Project #: 1009082 Application #: 13DRB-70632, 13DRB-70633

Project Name: City of Albuquerque

Subdivision Name: TRACT 1, BLOCK 2, VOLCANO CLIFFS UNIT 26

12DRB-70082 VACATION OF PUBLIC UTILITY EASEMENT
12DRB-70083 VACATION OF PUBLIC RIGHT-OF-WAY

**WILSON & COMPANY**  
4900 LANG AVENUE N.E.  
ALBUQUERQUE, NEW MEXICO  
87109  
(505) 348-4000  
SHEET 2 OF 2  
WCI PROJ. NO. 08-400-104-00

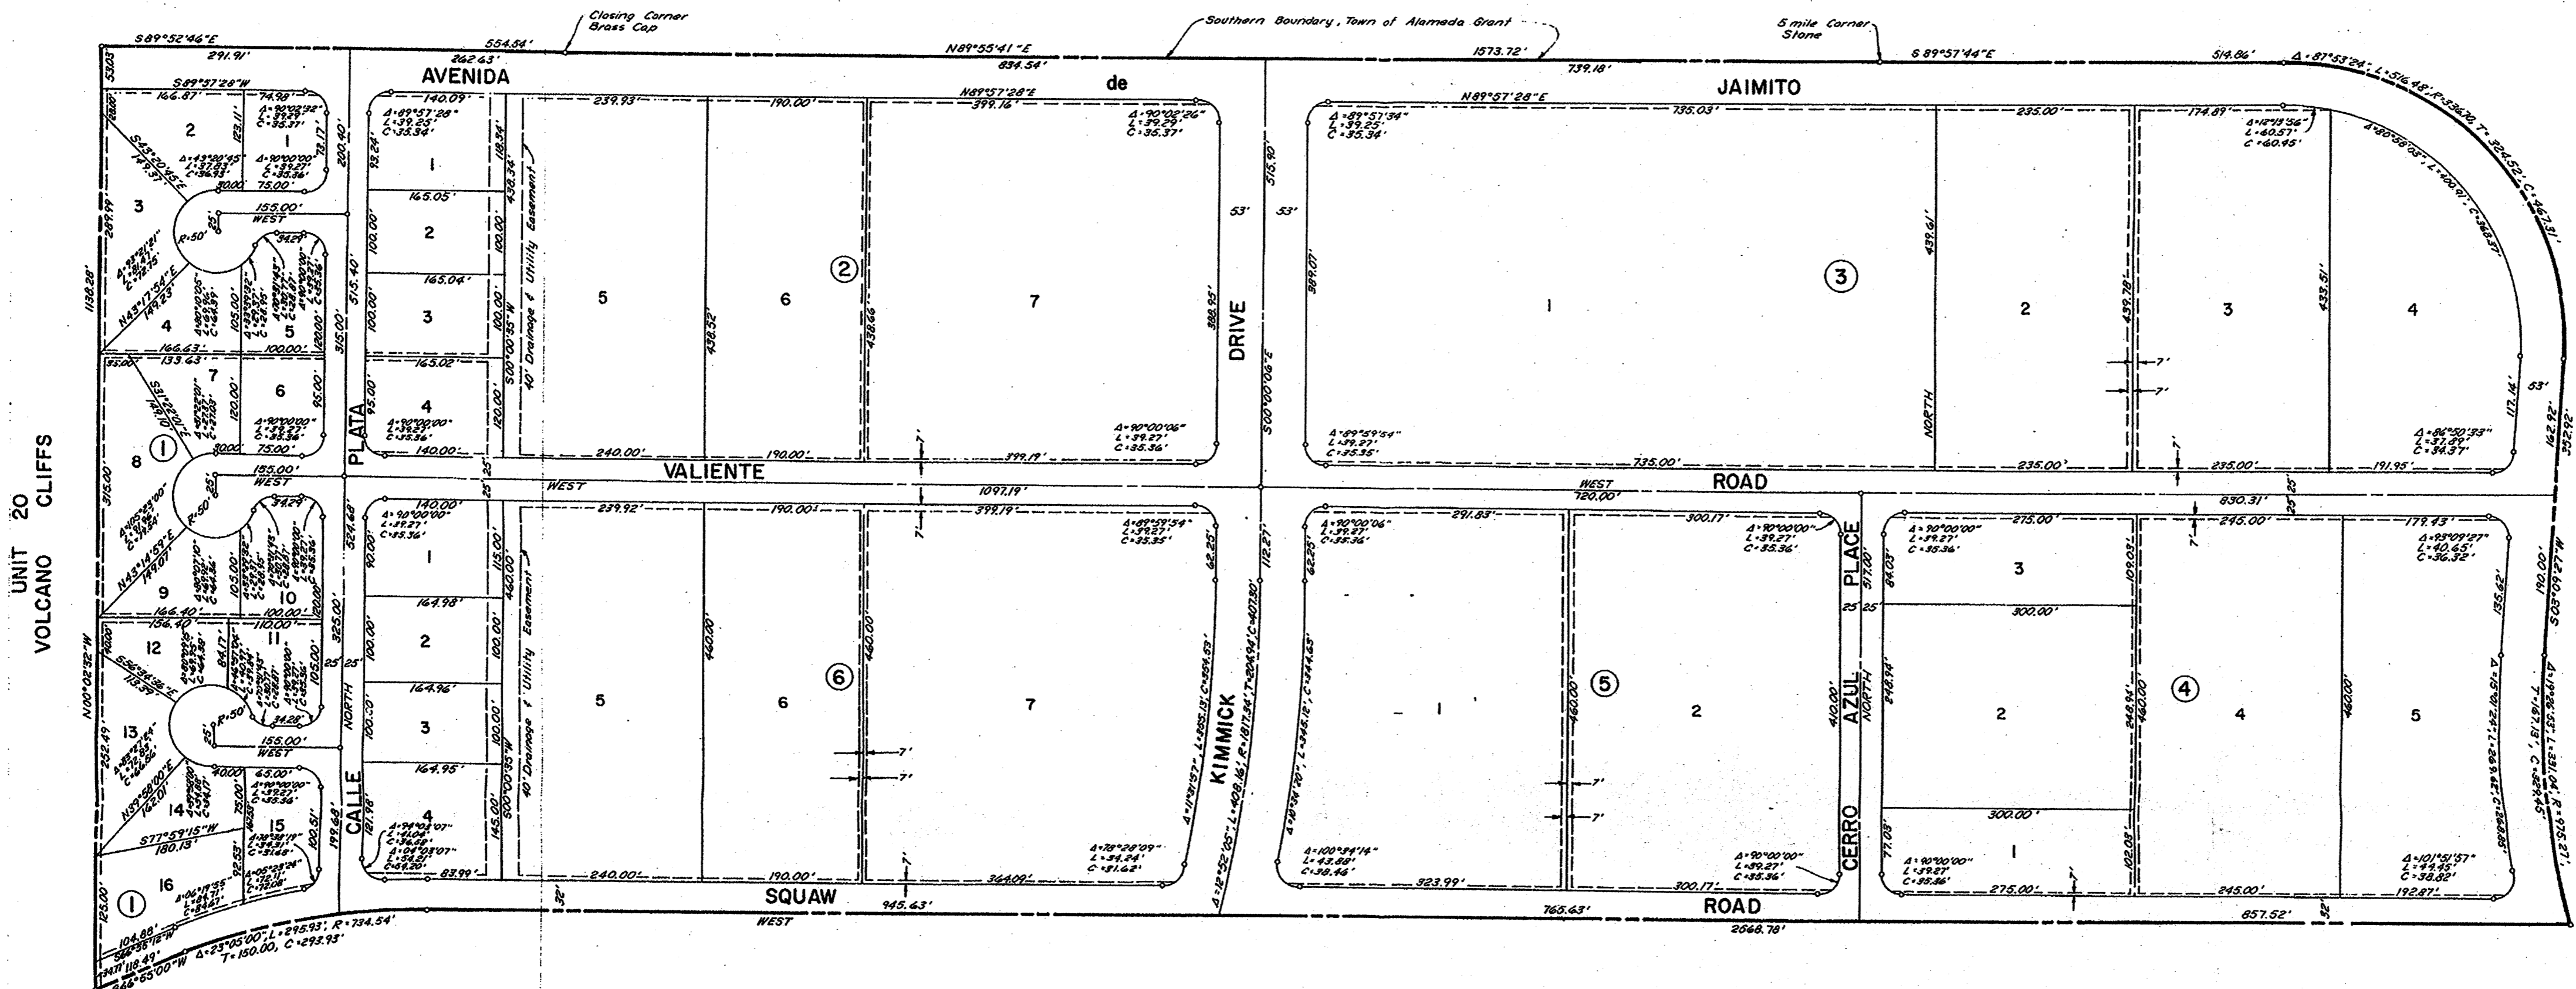
Provide an exhibit showing the location of sidewalk and defining the distance from face of curb to the property line. Right of way dedication may be required.

Provide cross sections for the proposed roadway sections.

What is the roadway classification of Kimmick Drive and Rosa Parks Road? Larger radii may be required at the intersection of Kimmick / Paseo del Norte and Kimmick / Rosa Parks.

Is a traffic signal proposed at Kimmick / Paseo del Norte?

Does Valiente Road meet the criteria for a stub street (maximum number of units is 4 and the maximum length is 150' measured from the centerline of the intersecting street to the end of the stub street)?

Define the full right of way width of Paseo del Norte (156' ultimate).

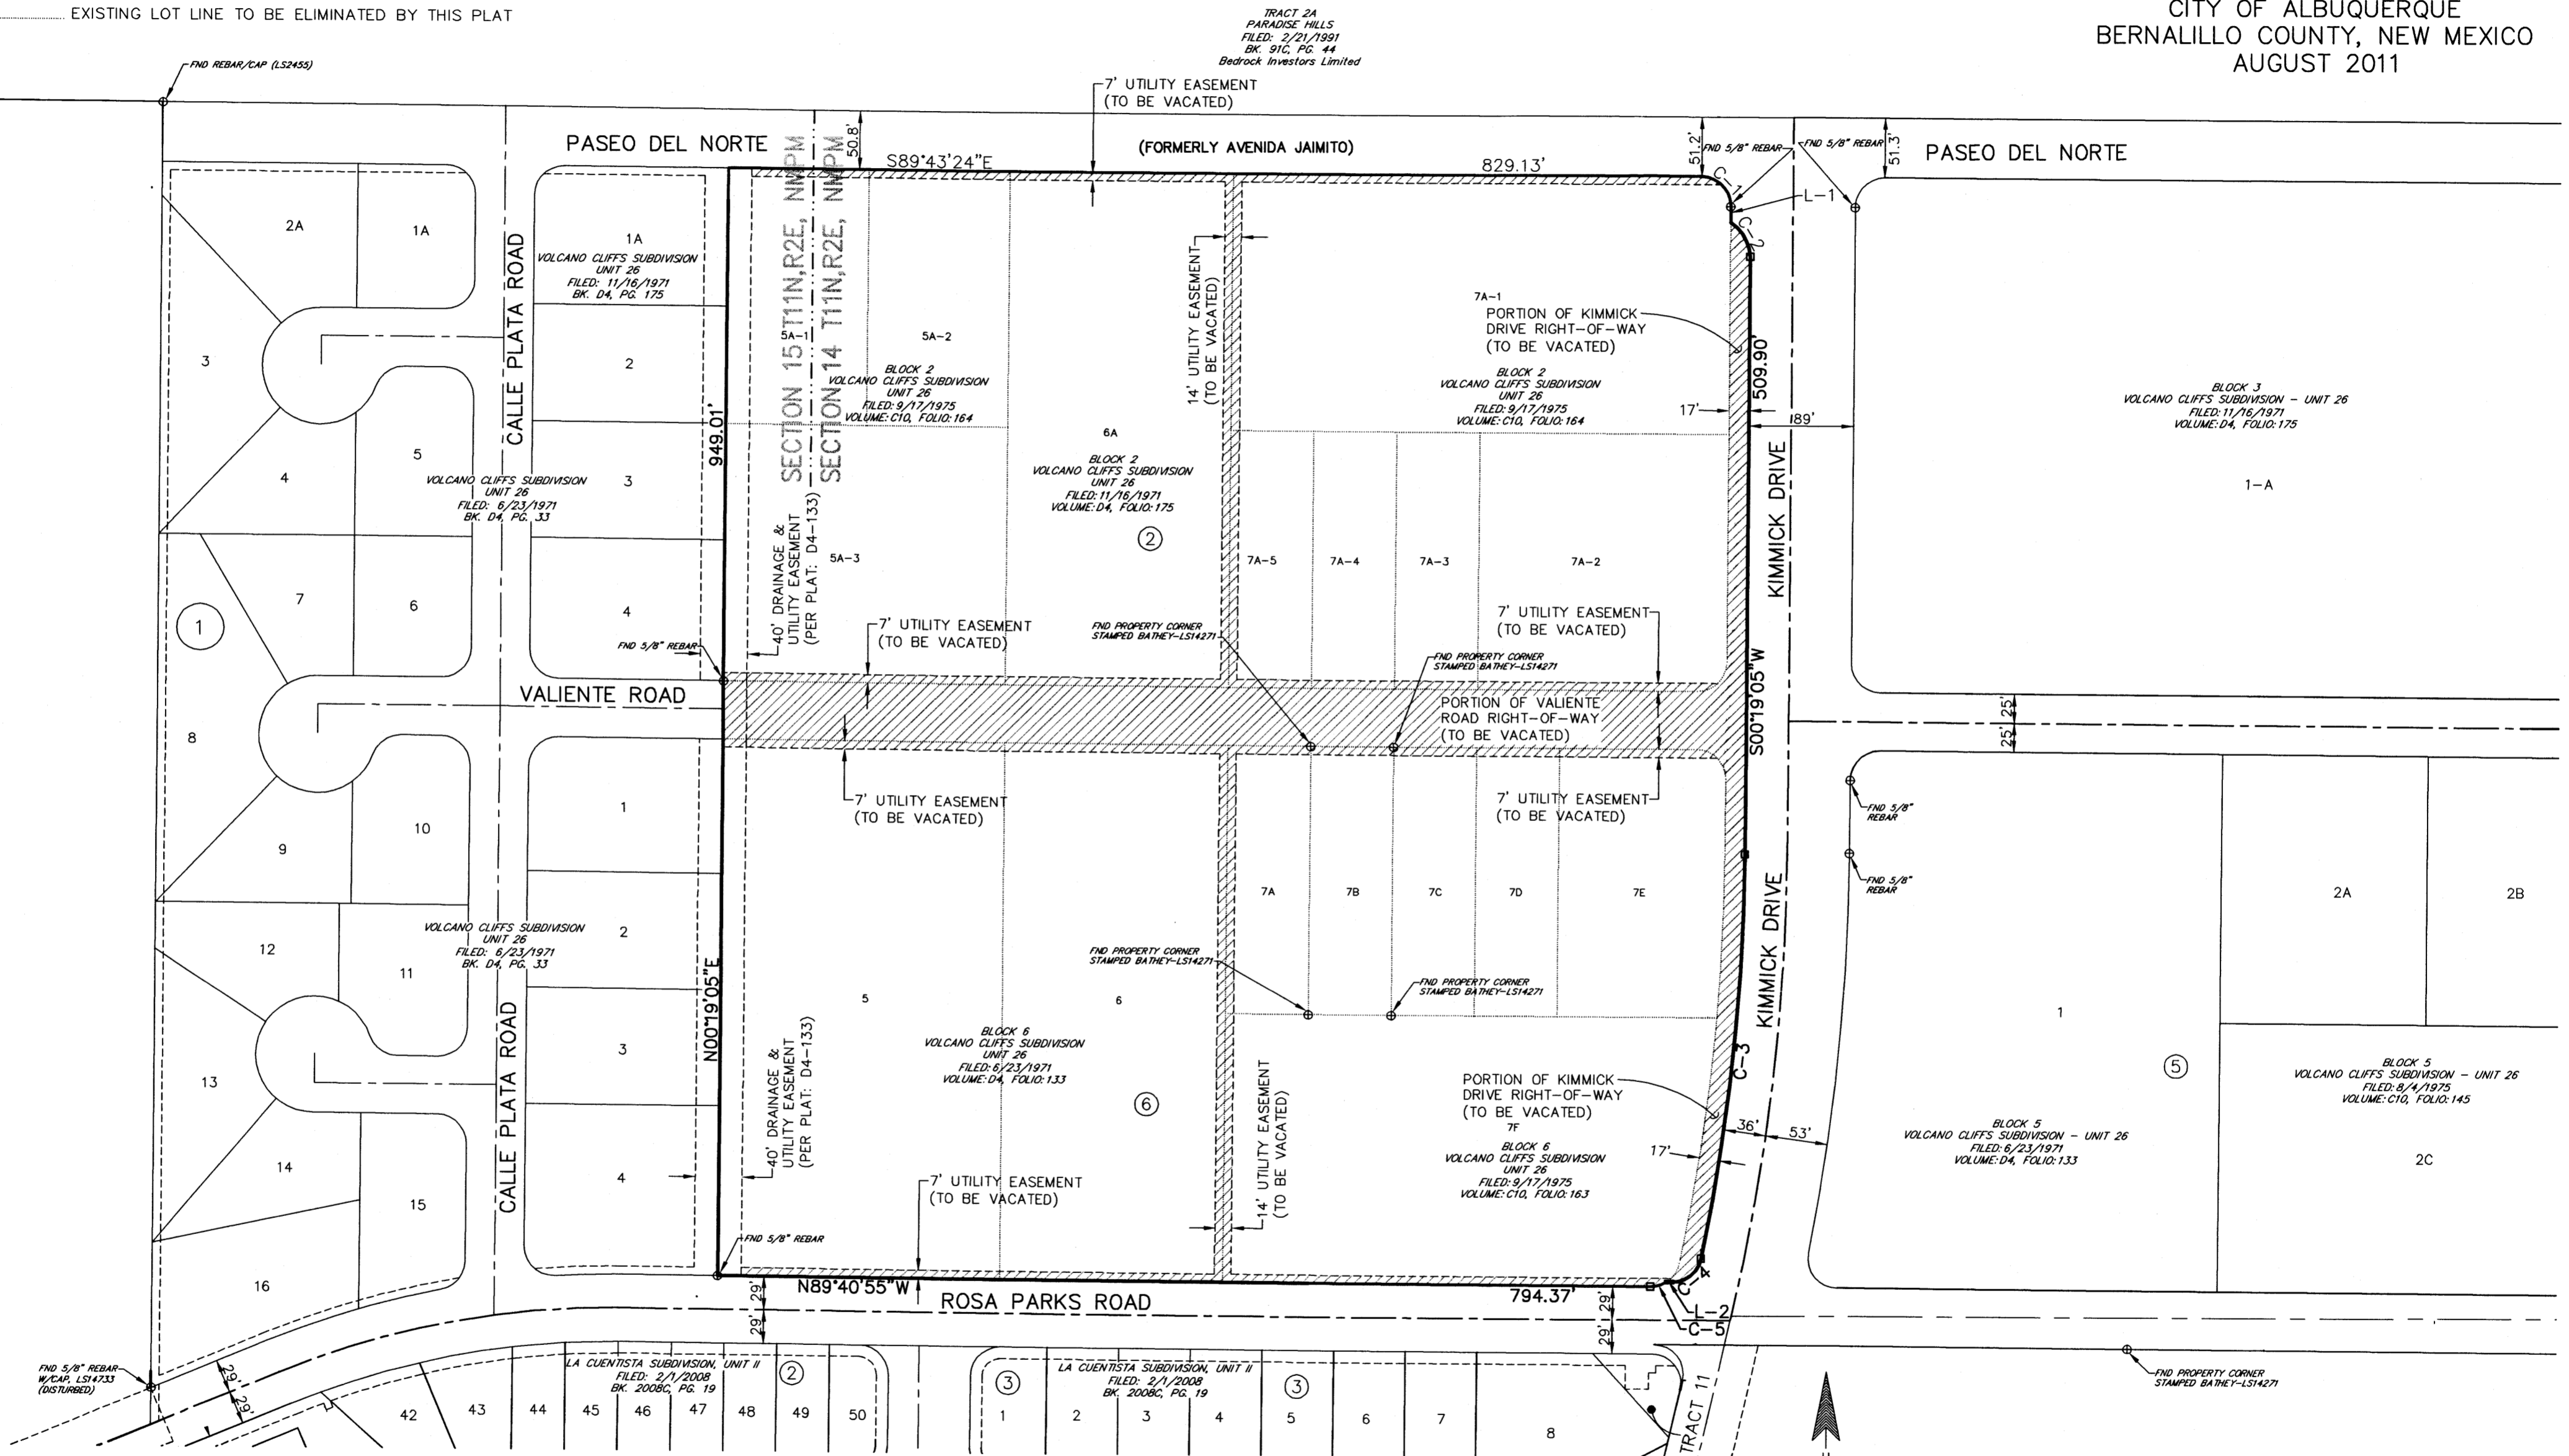
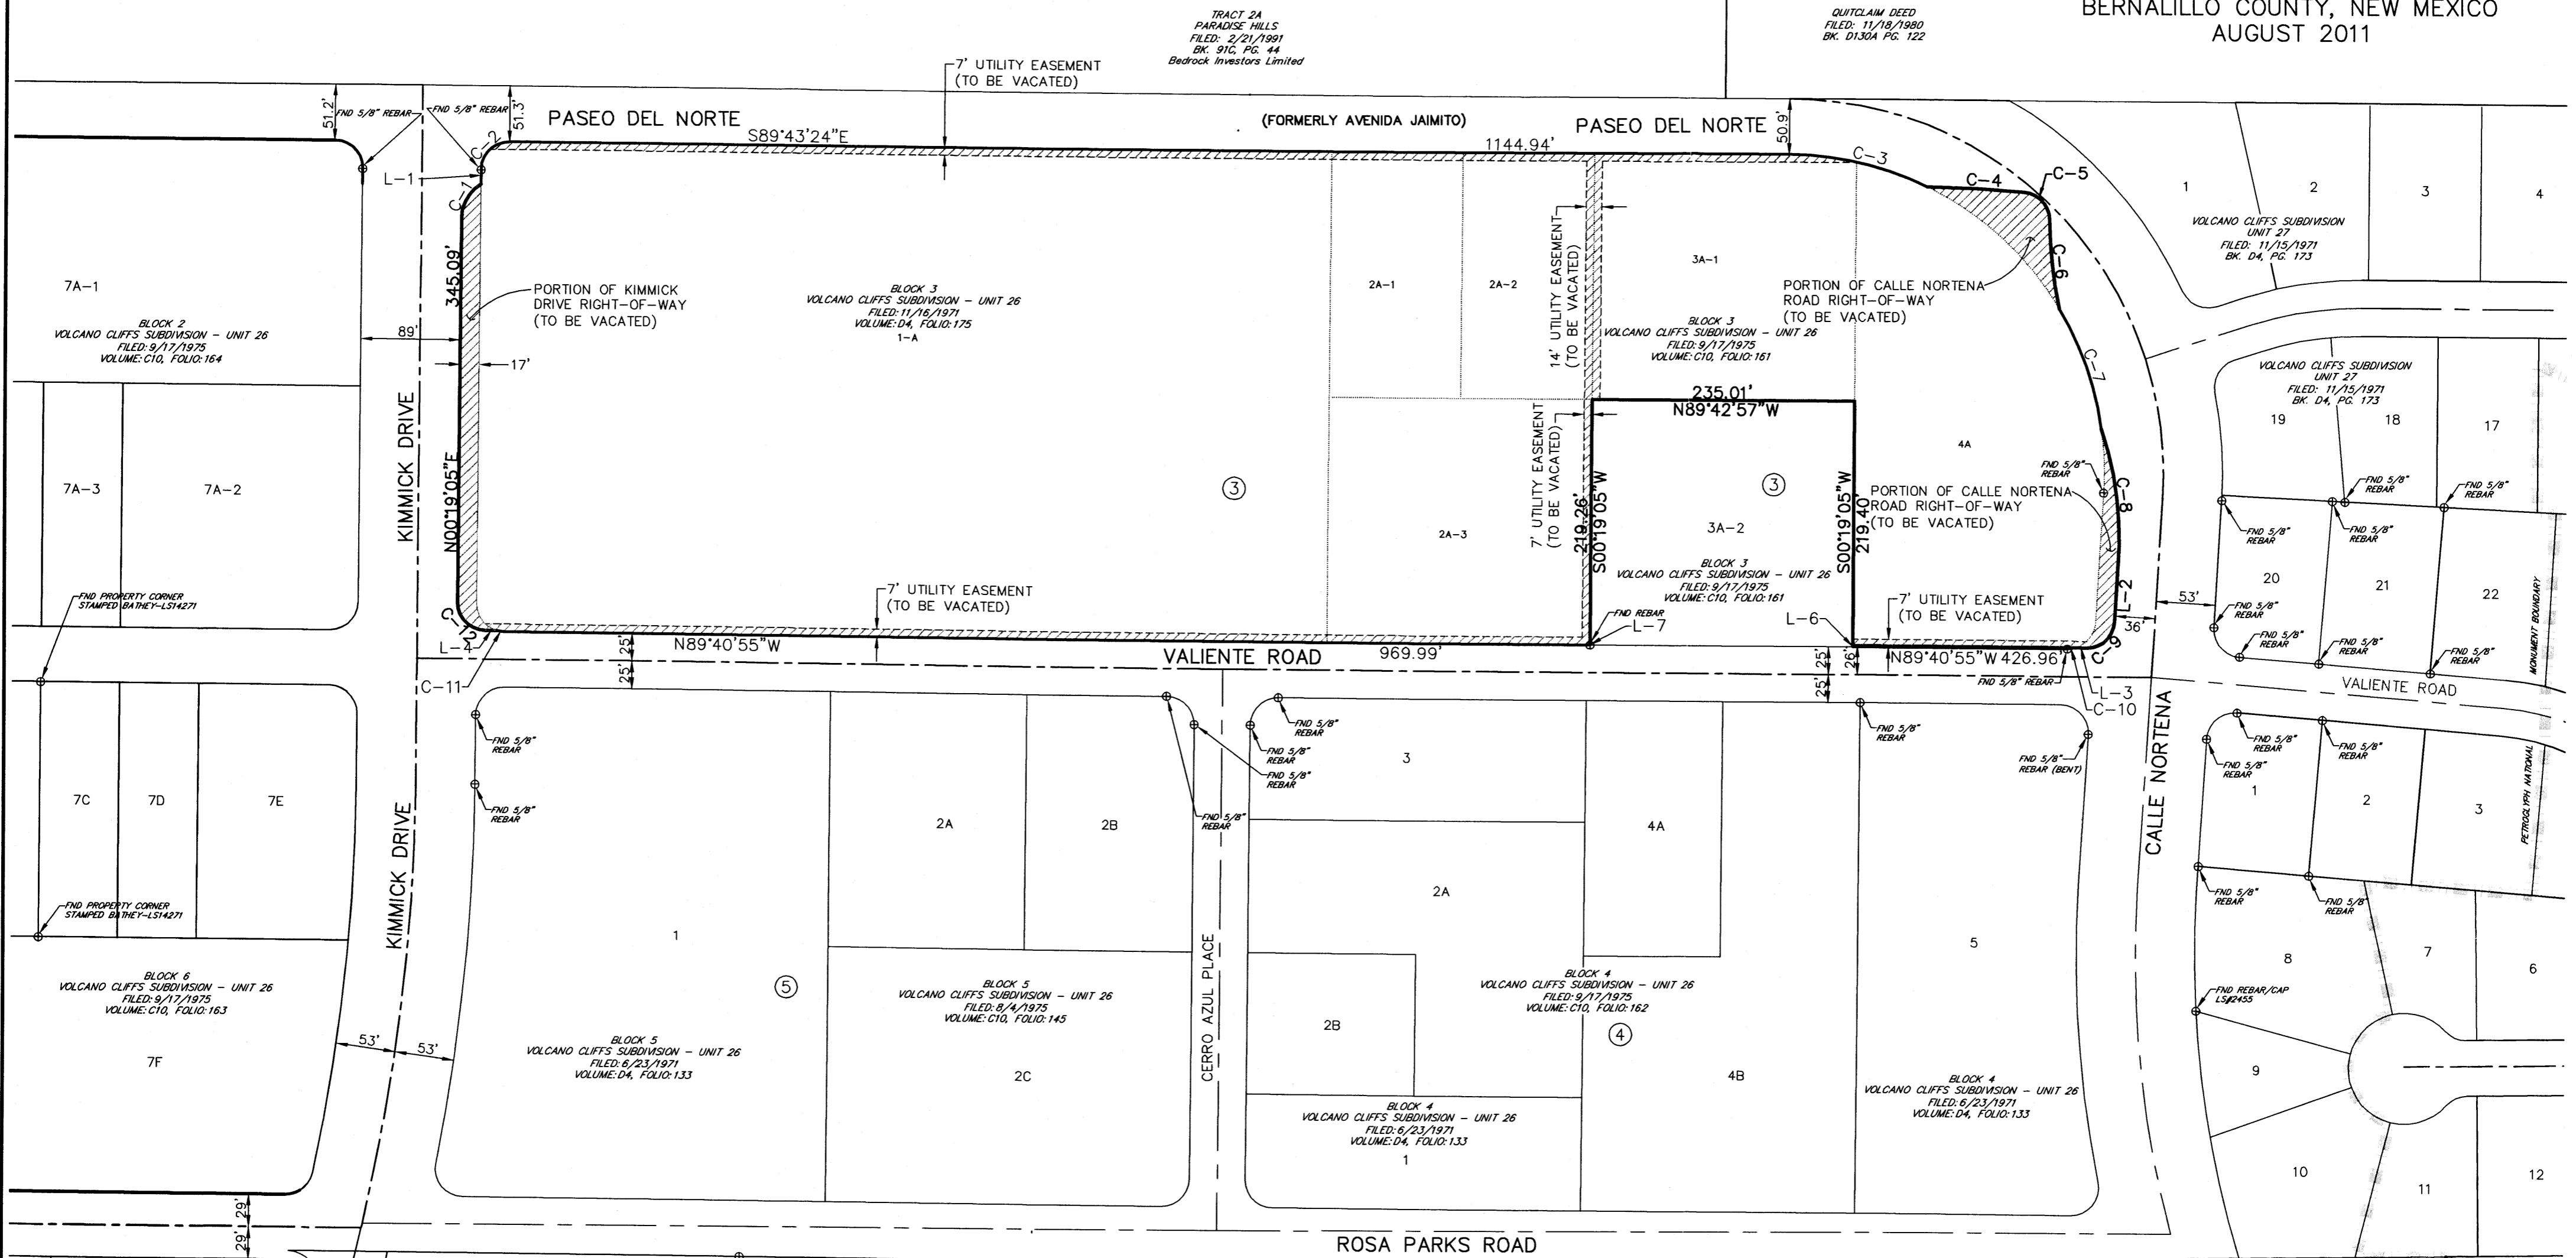
The area of the vacation appears to drain north to south and therefore not down this portion of Valiente Rd. Therefore, Hydrology has no objection.

Hydrology defers to Transportation.
